West Yorkshire Police
Kirklees District

Designing Out Crime Officer

To: Stuart Howden Kirklees Council Planning Services Civic Centre 1, High Street, Huddersfield, HD1 2NF	Ref: 2020/91474 Date: 11 th November 2020
--	---

Site Location: Former scrap yard at Canalside West, Firth Street, Huddersfield, HD1 3DB
Application : Formation of 55 parking spaces

Proposed Perimeter Fencing
Scale 1:20

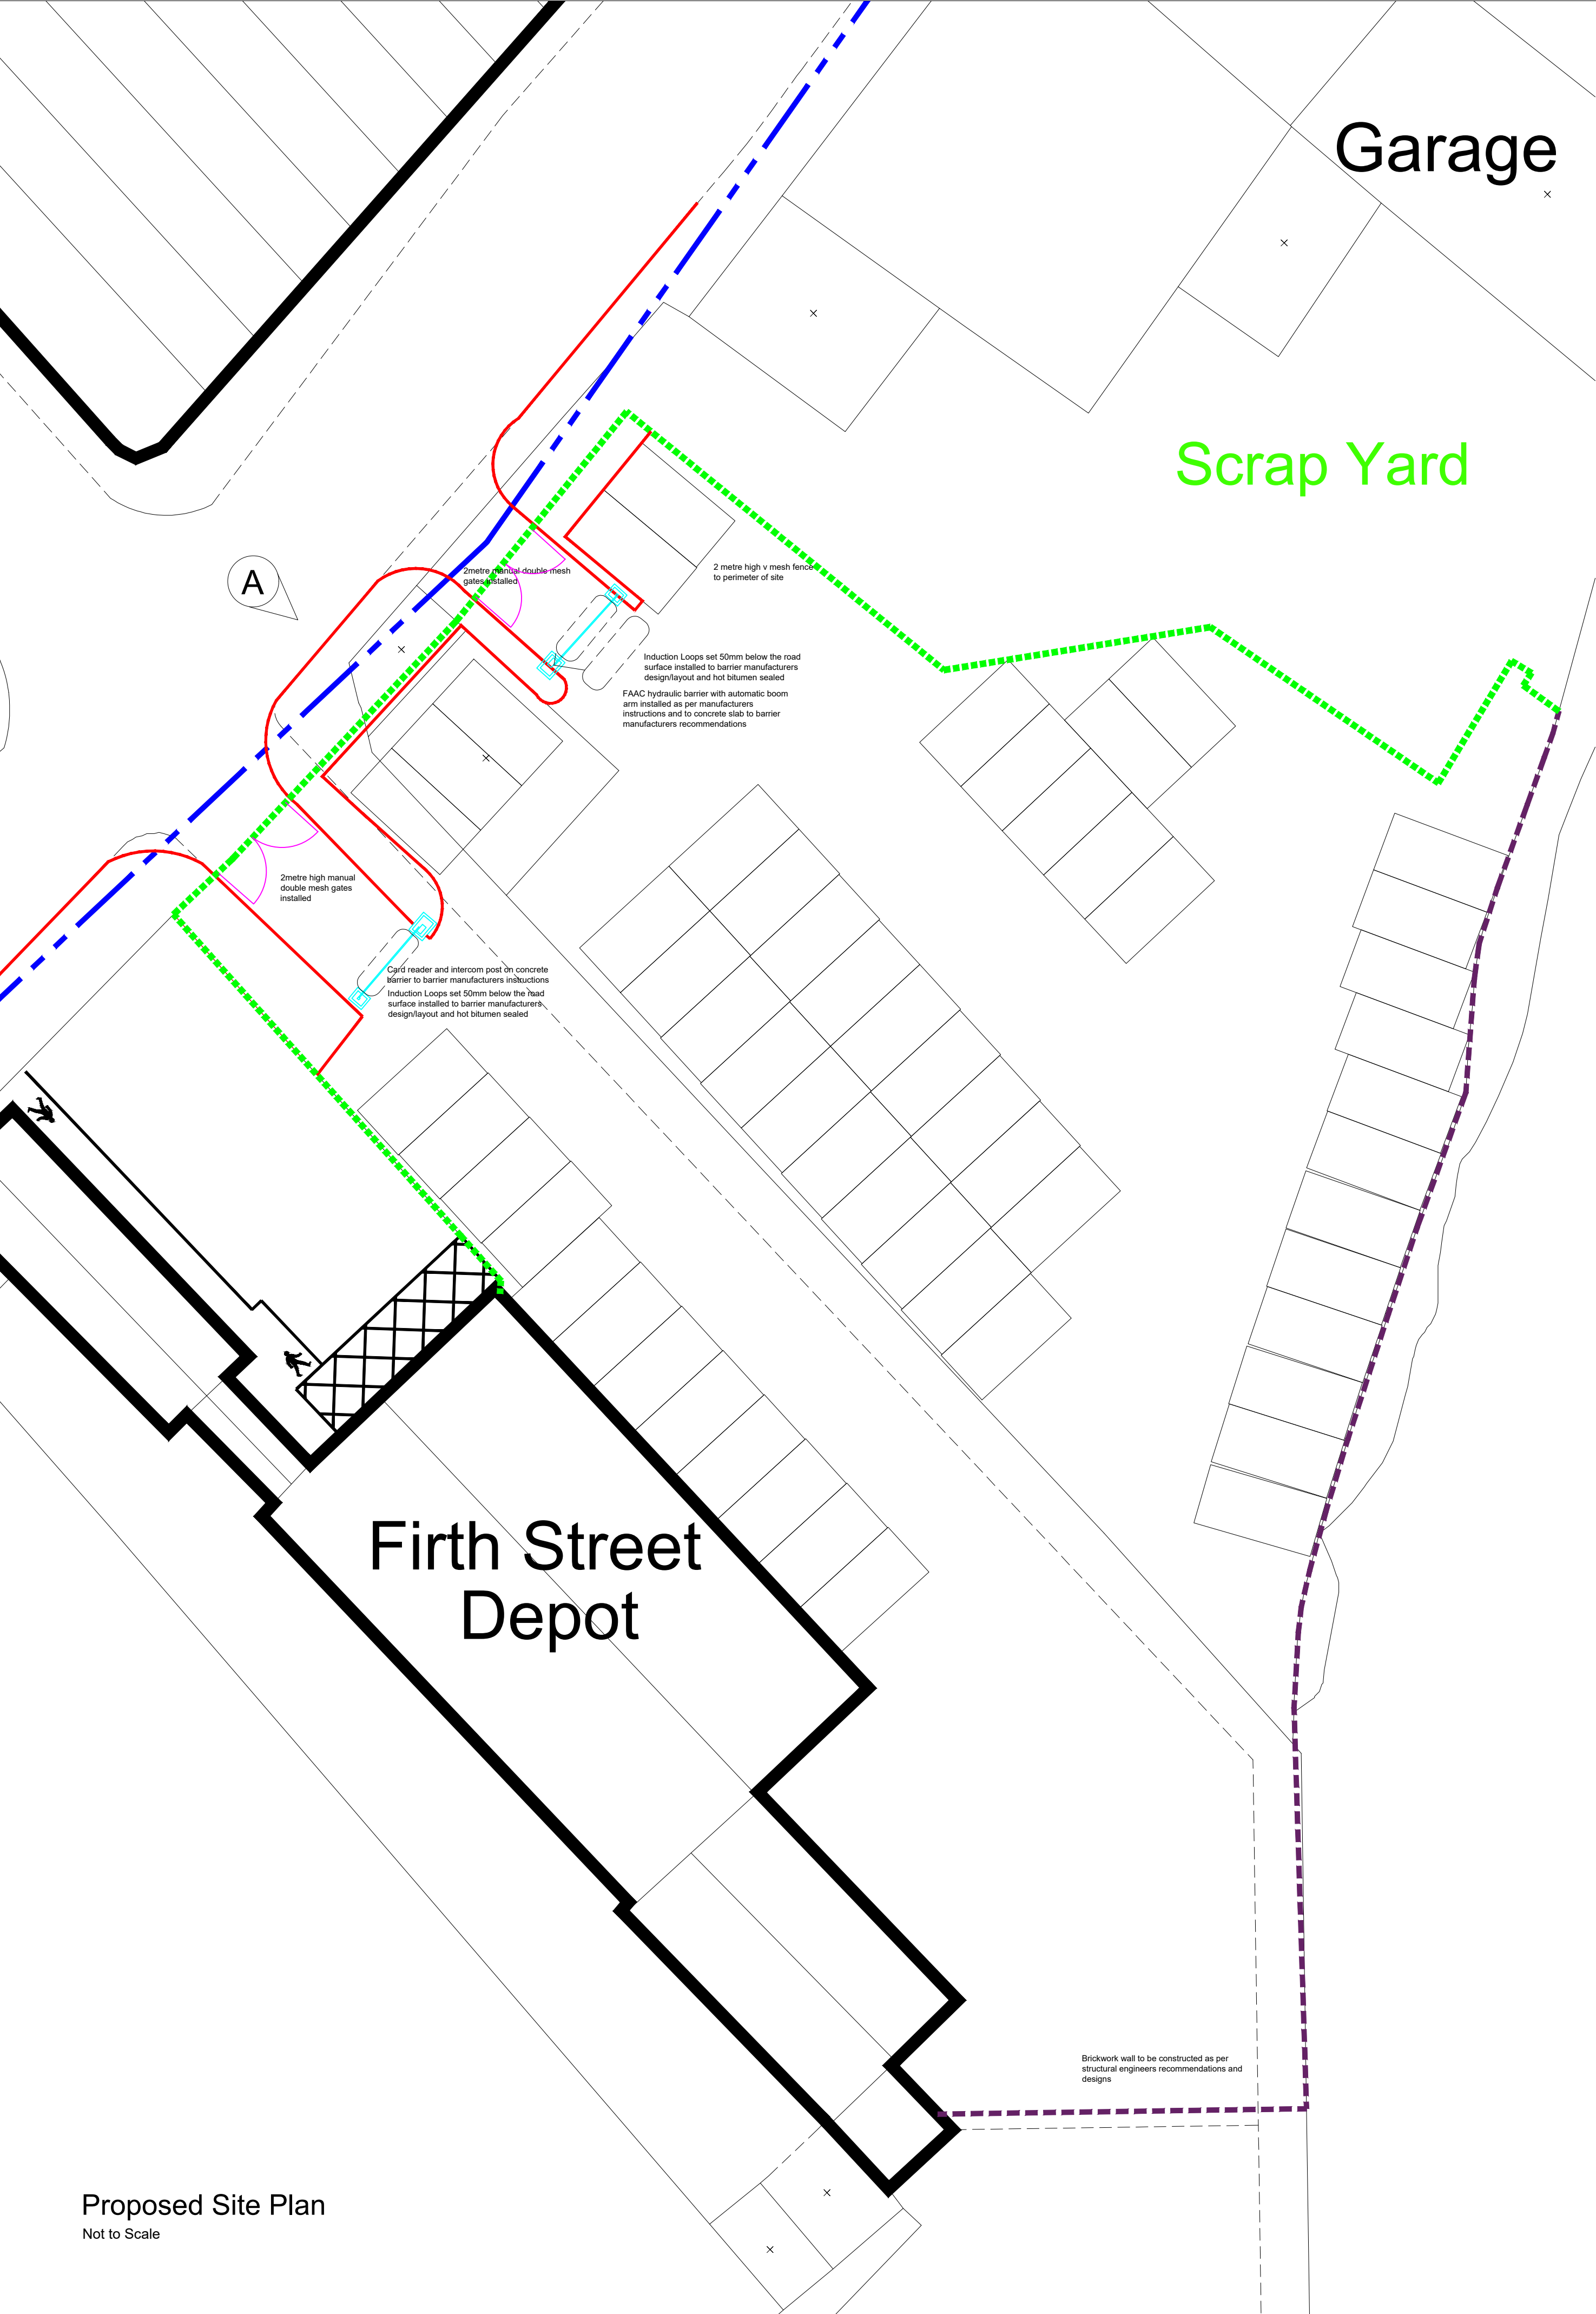
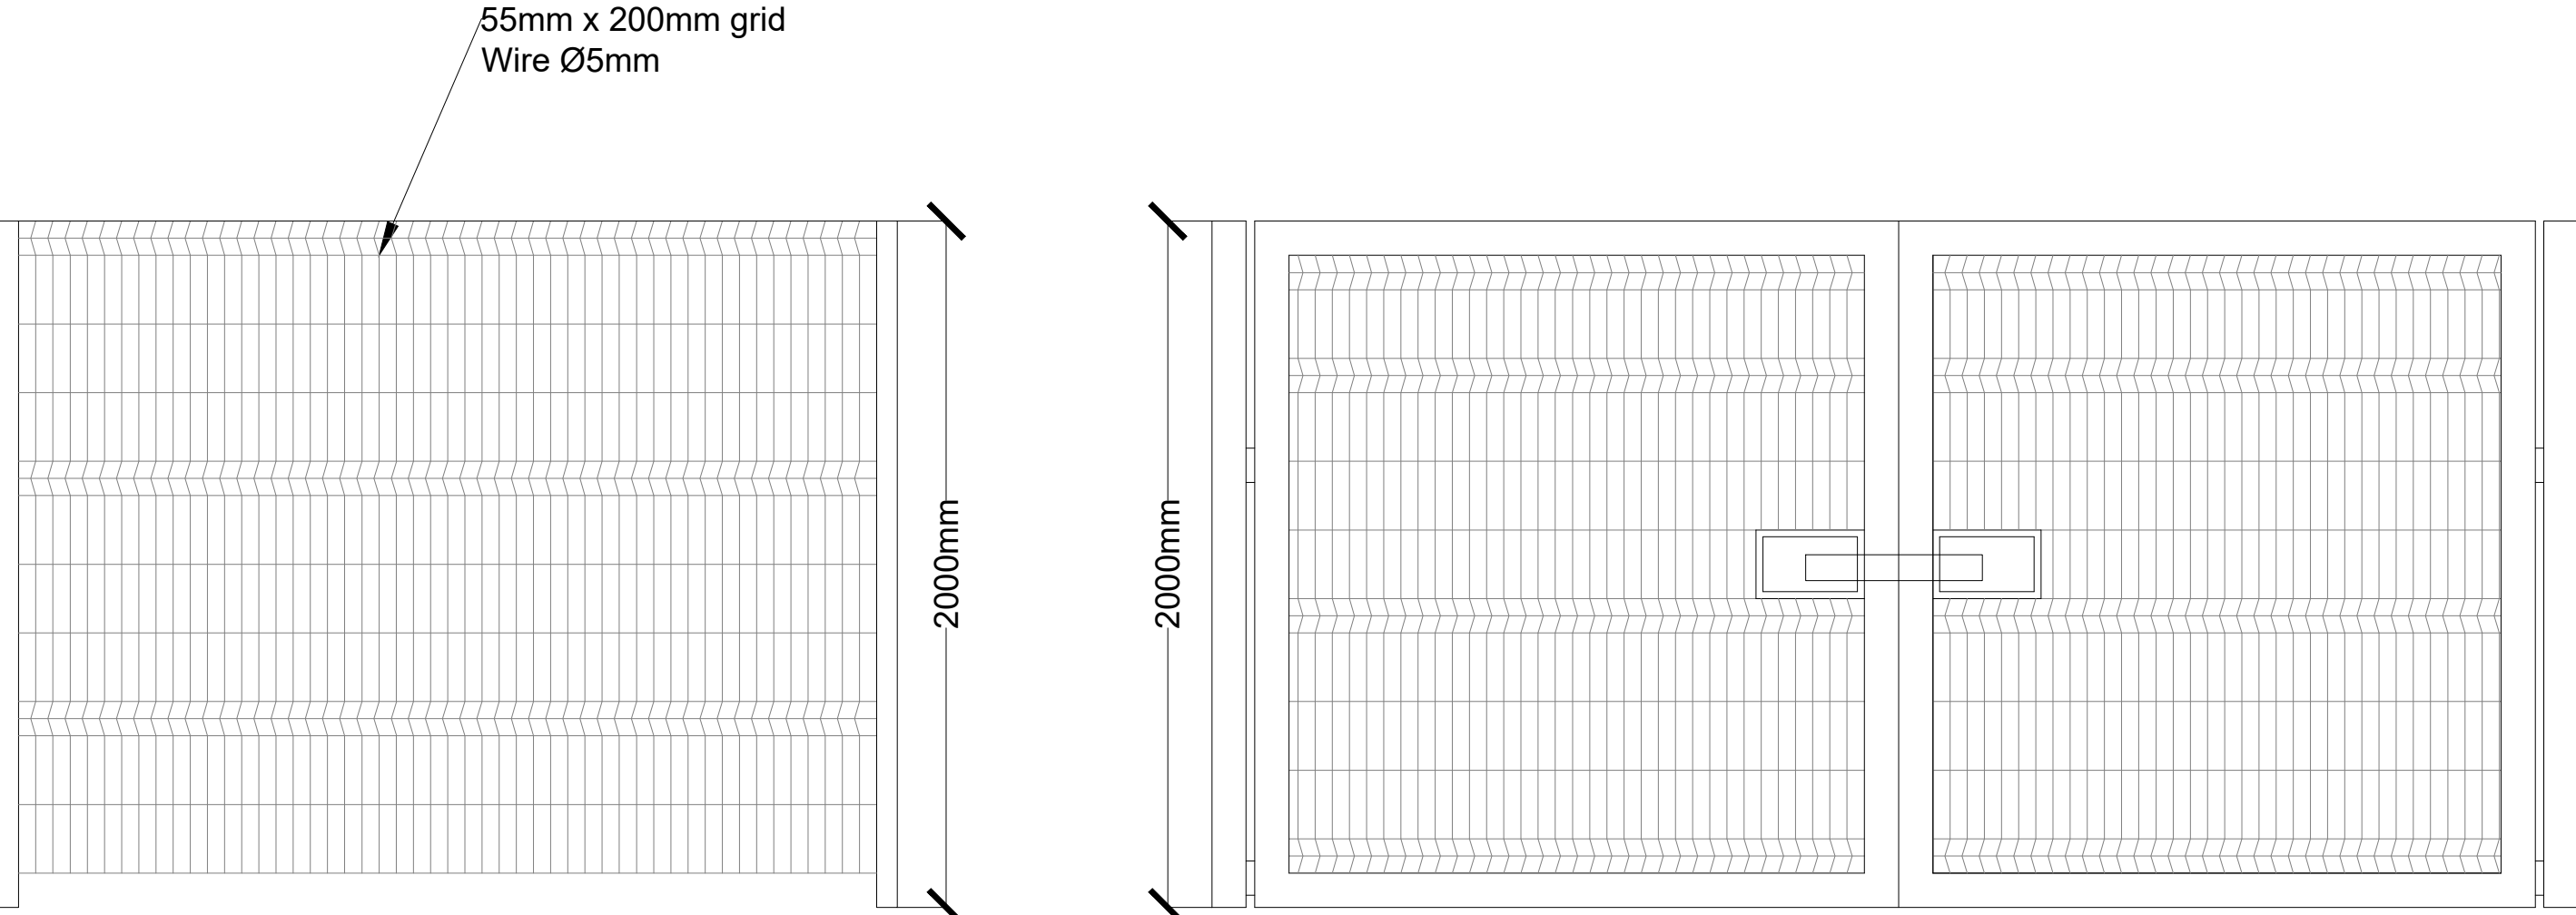
It is essential that all fencing and boundary treatments be designed so that the external face is flat with no footholds for climbing. This applies to any gates used on the site as well.

The design, height and construction of any gates within a perimeter fencing system should match that of the adjoining fence and not compromise the overall security of the boundary.

Access must be restricted to the perimeter defensible space from public land by installing a lockable gate of the same material and same height as the fencing. It is advised that the gate construction is such that no footholds or cross members are accessible from the outside of the gate, especially around the locking mechanism to prevent climbing.
